**ENVIRONMENTAL IMPACT STATEMENT
STUDENT ACCOMMODATION
104-116 REGENT STREET, REGENT**

Thank you for referring the Environmental Impact Statement (EIS) for SSD-10720865 'Redfern Mixed Use Boarding House Development' to Transport for NSW (TfNSW) for review and comment.

TAB A – Advisory comments and suggested conditions of consent

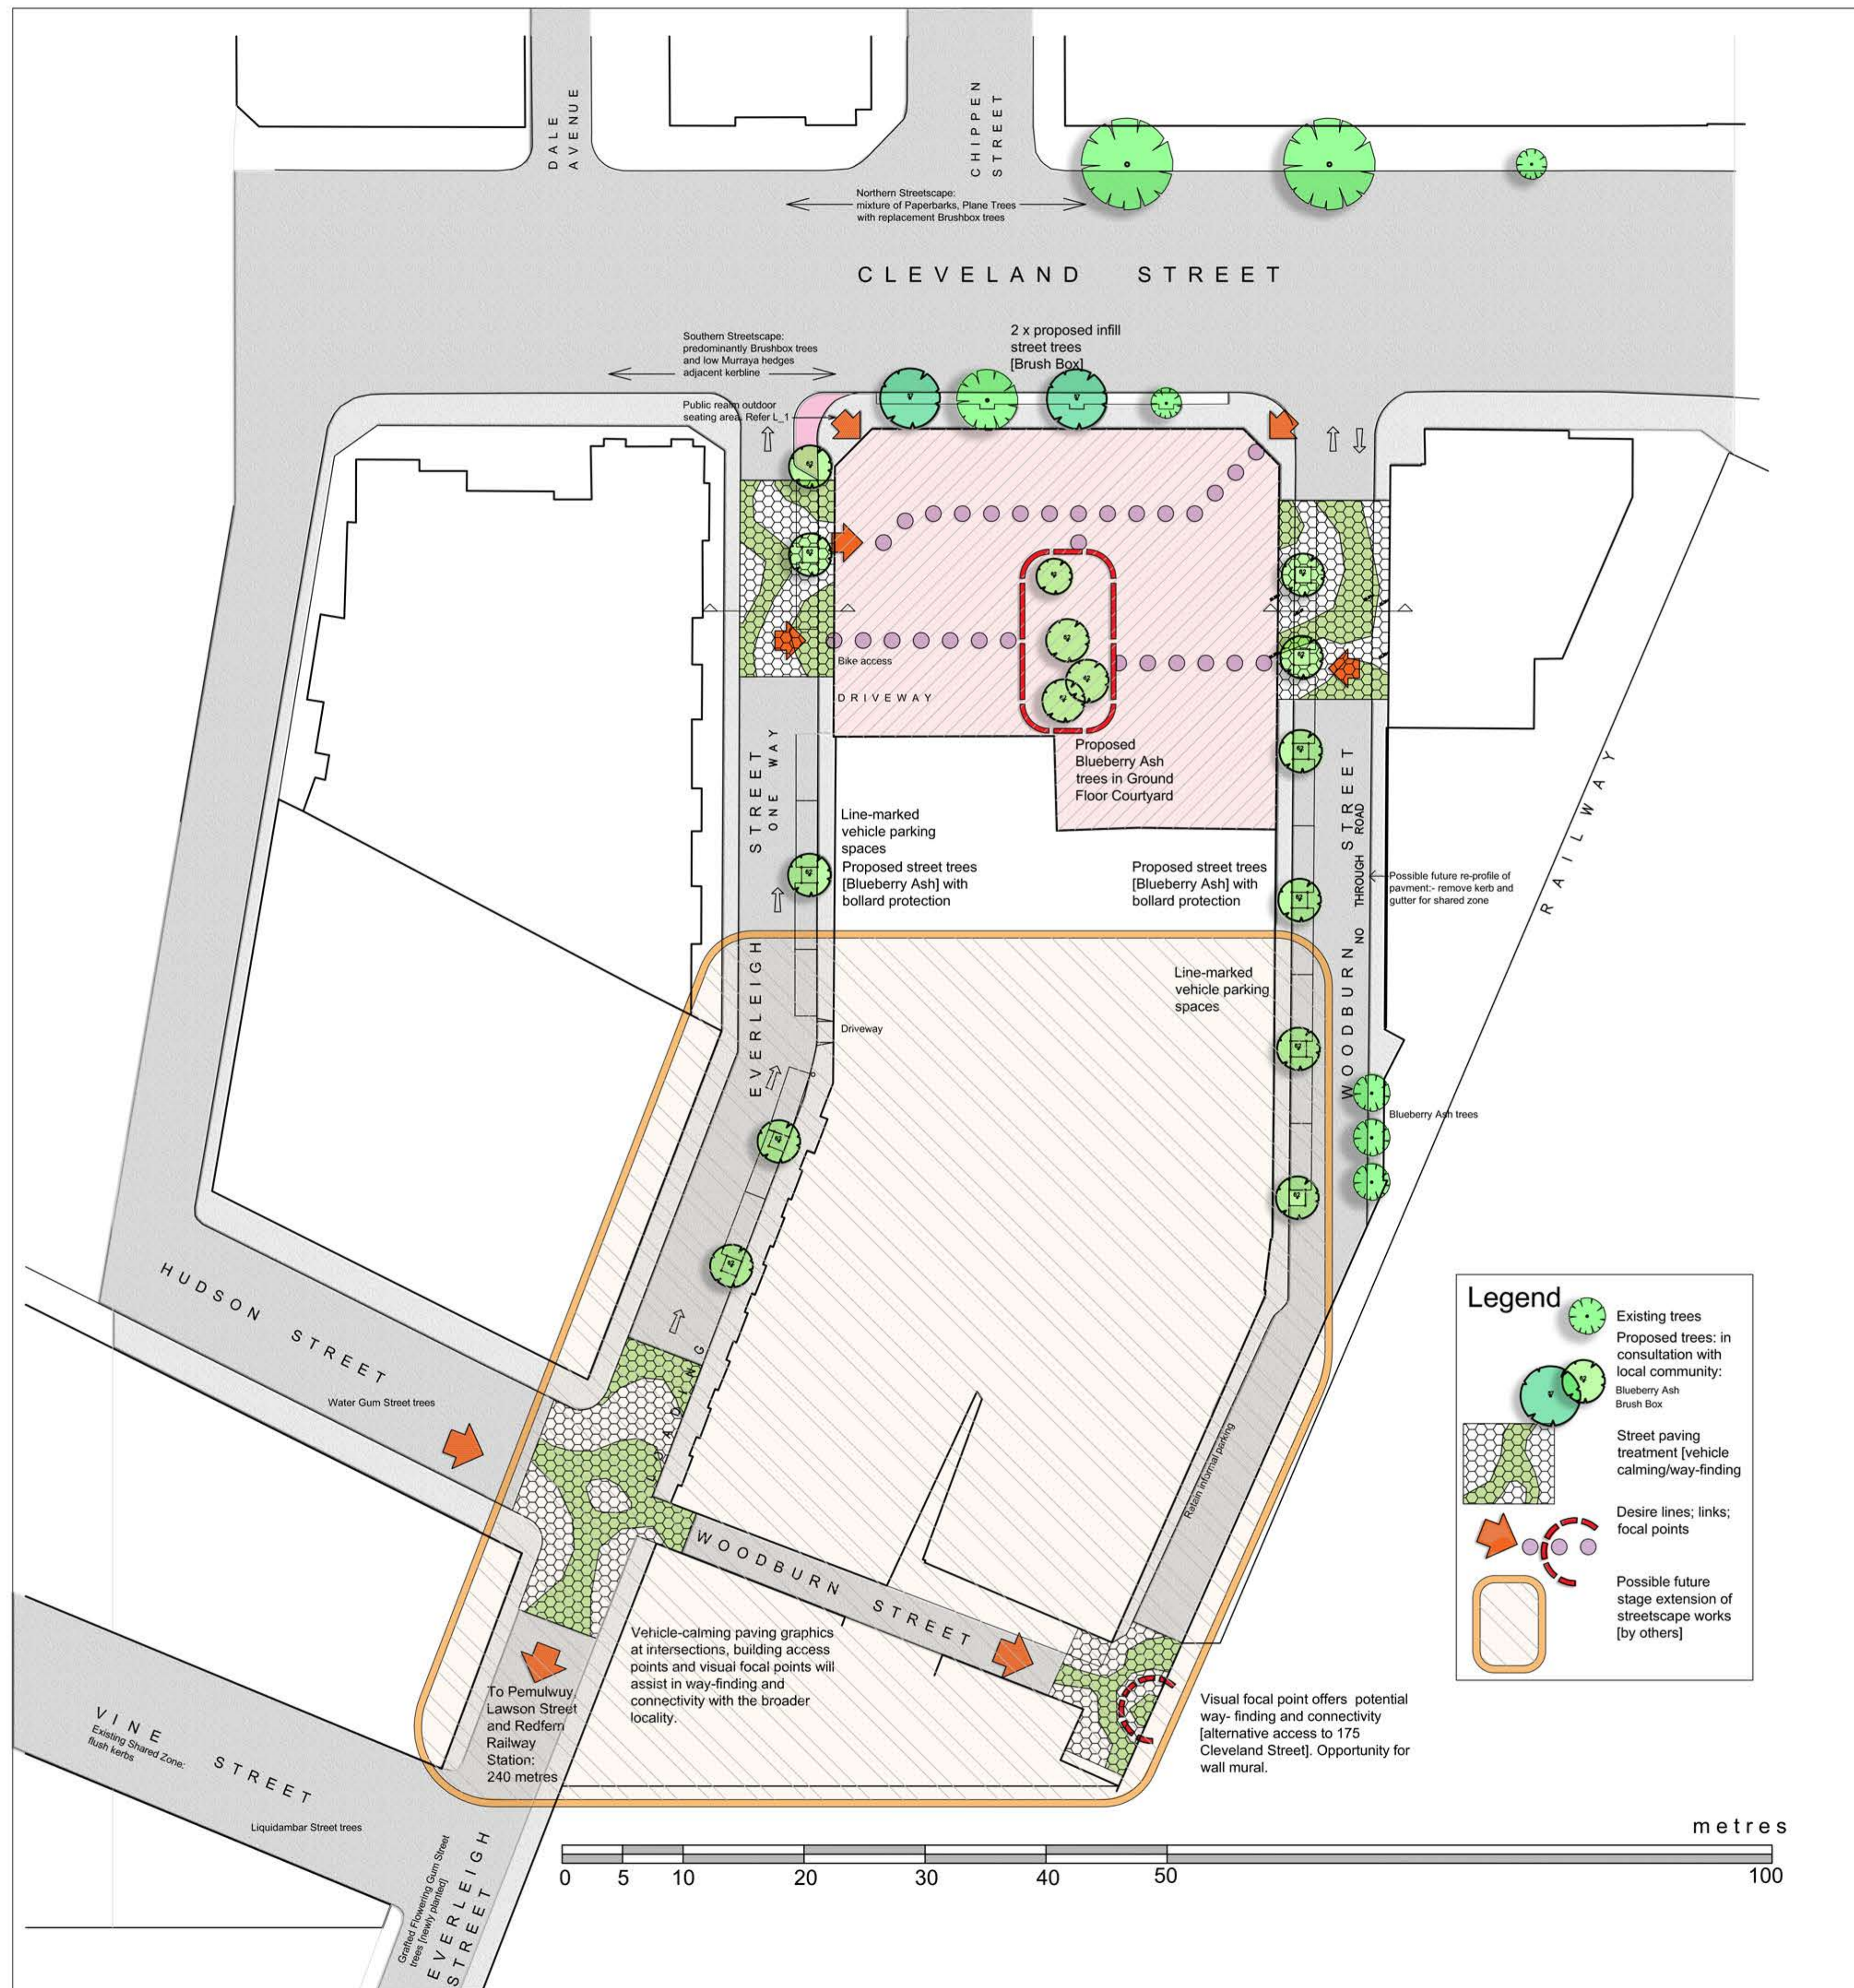
- The built edges of all street frontages at the ground floor level should be designed to maximise activation with clear glazing and active uses, to contribute to vibrancy of the area and passive surveillance.
- The proposed southern setback and western through site link should be designed as welcoming, attractive, and accessible public spaces, maximising permeability and connectivity.

TfNSW recommends that the Applicant addresses the above matters as part of the Response to Submissions (RtS).
